Department of Planning, Industry & Environment
GPO Box 39
Sydney NSW 2001

Application No: SSD-10831778

Re: Randwick City Council submission on the State Significant Development SSD-10831778 – Sydney Children’s Hospital Stage 1 and Children’s Comprehensive Campus Centre (SSD-10831778)

ELEVATION 02 - WEST
1:200

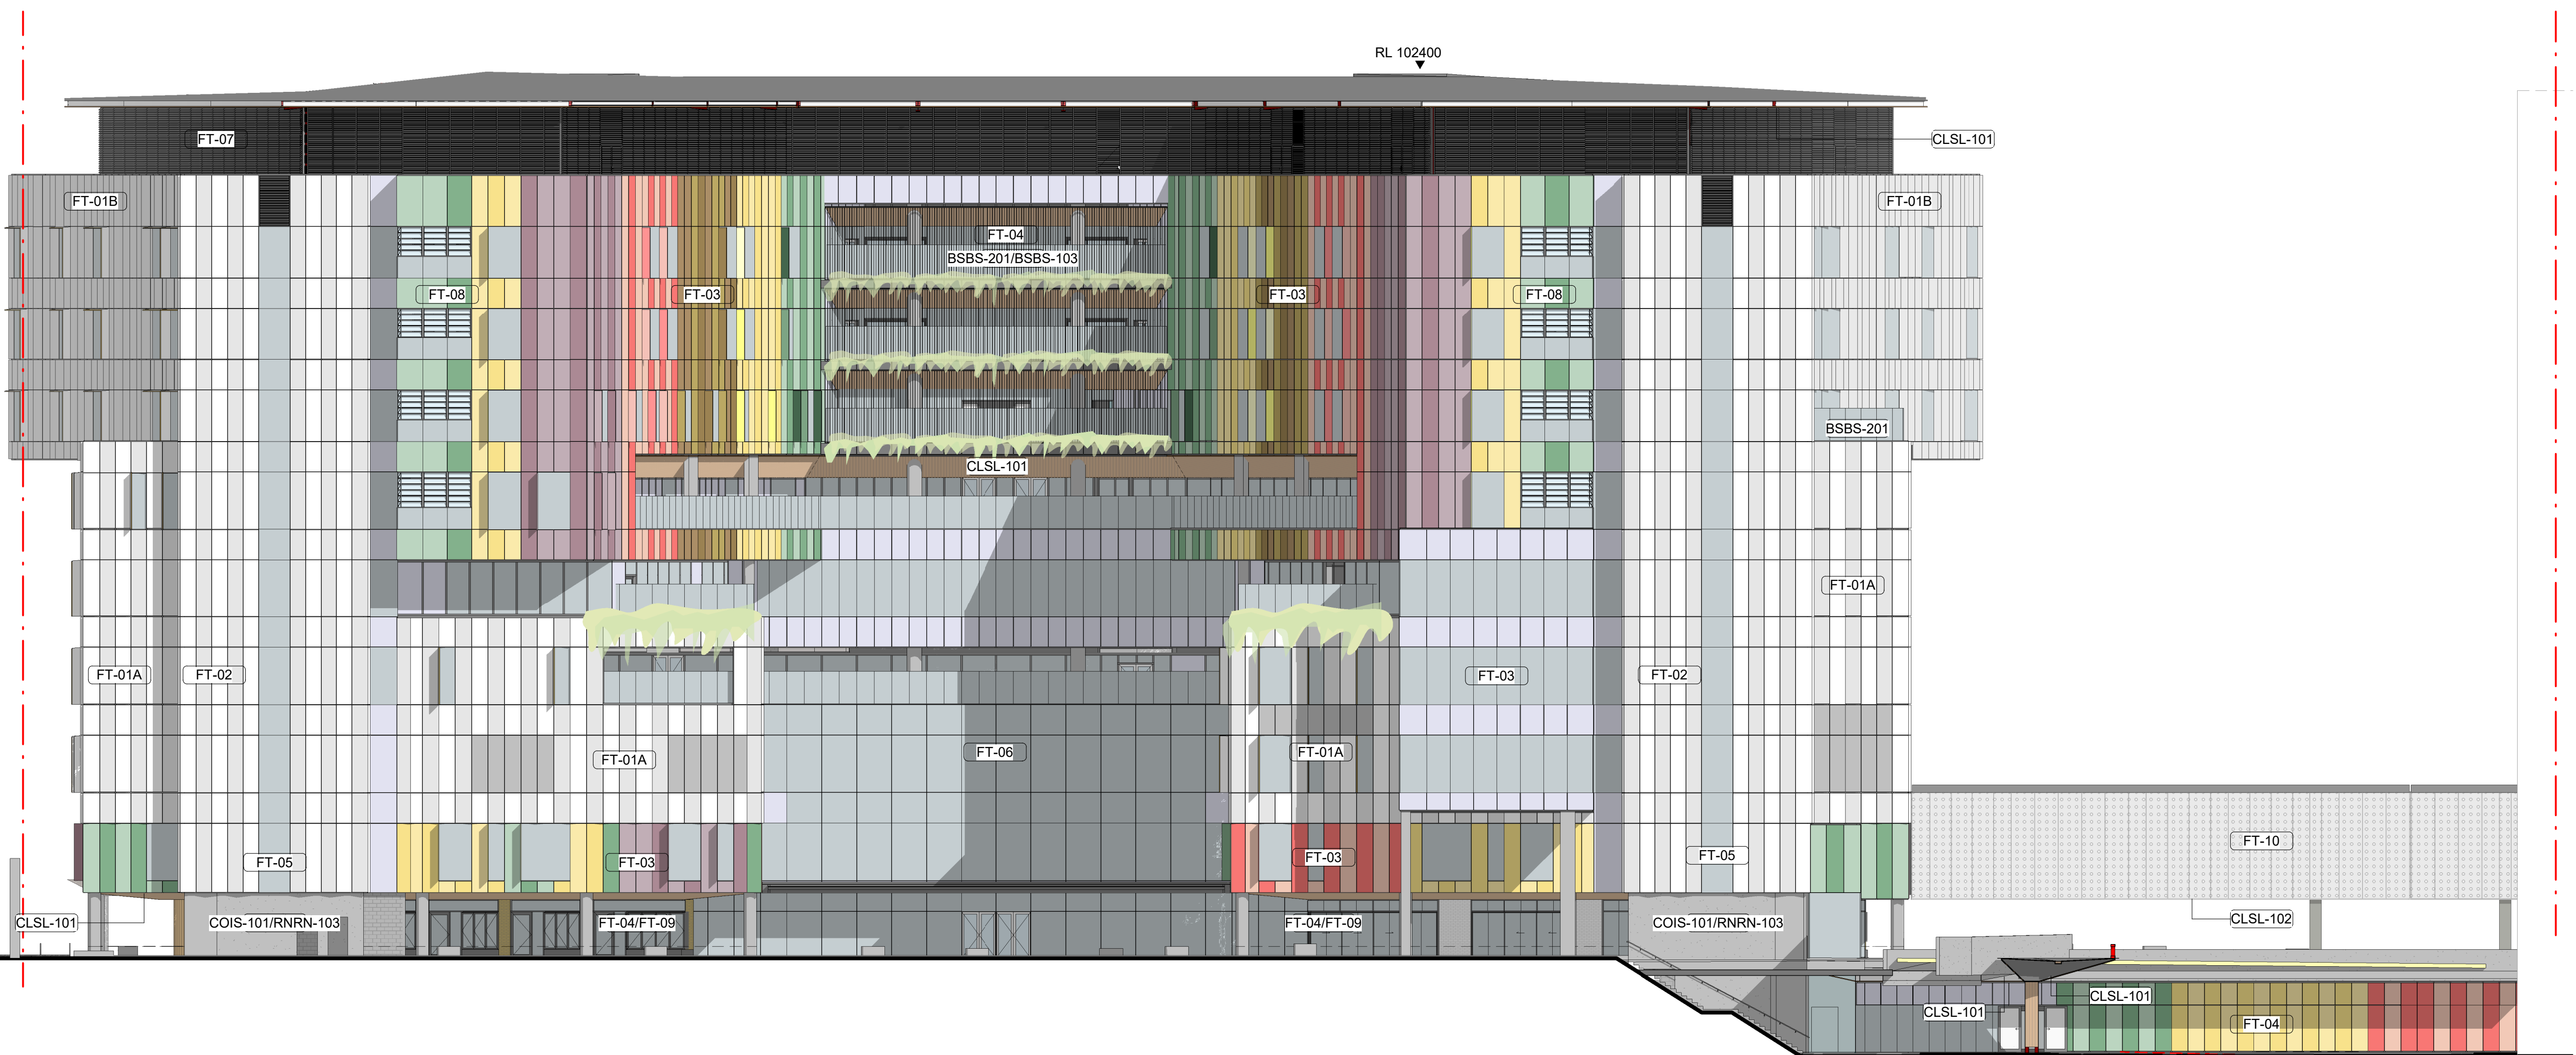
31. The southern Integrated Acute Services Building (IASB) link bridge is two storeys high and crosses over the children's play area. The bridge is low to the ground and is somewhat heavy in appearance. It is recommended that the bridge is redesigned and refined to maximising the visual openness beneath the bridge and the transparency of the bridge to deliver a thinner profile and fineness of detailing and expression. Rather than repeating the vertical cladding of the main building on the bridge element, a contrasting light steel and glass architectural expression would provide a more successful outcome. A similar approach should be taken for the eastern Children's Hospital link bridge.
